Application No: BR/83/22/PL
Site Address: Unit 10 Arun Business Park Shripney Road Bognor Regis PO22 9SX
Description of works: Addition of two first floor windows at rear of property. This application is in CIL Zone 4 (Zero Rated) as other development.

Thank you for your internet representation made on 3rd May 2022 which has been recorded as an objection with the comments as follows:

Proposed Office Layout
Option #1

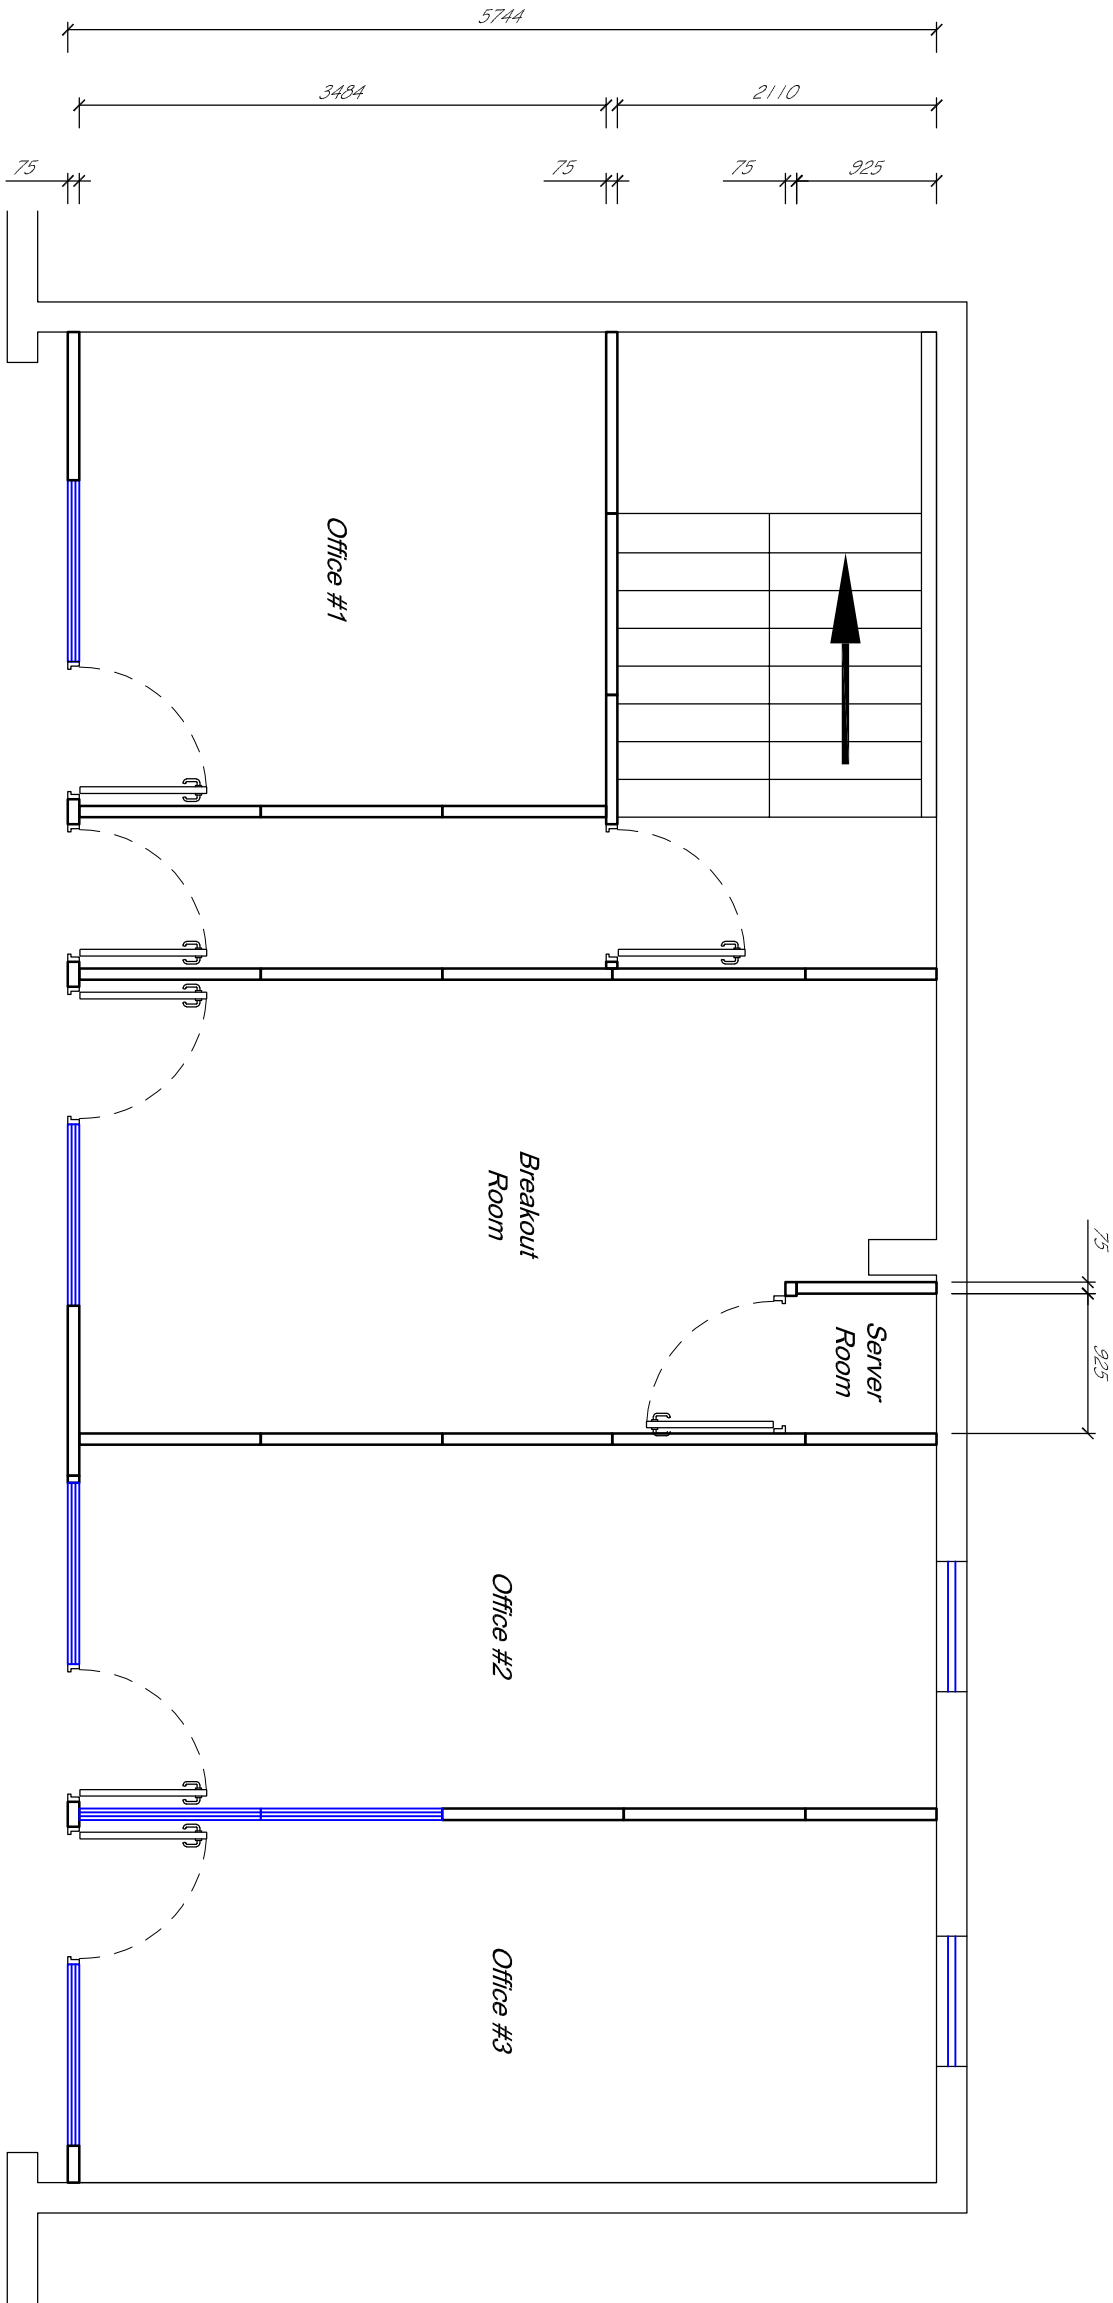
It will over look garden, it will infringe our privacy in the garden, kitchen etc
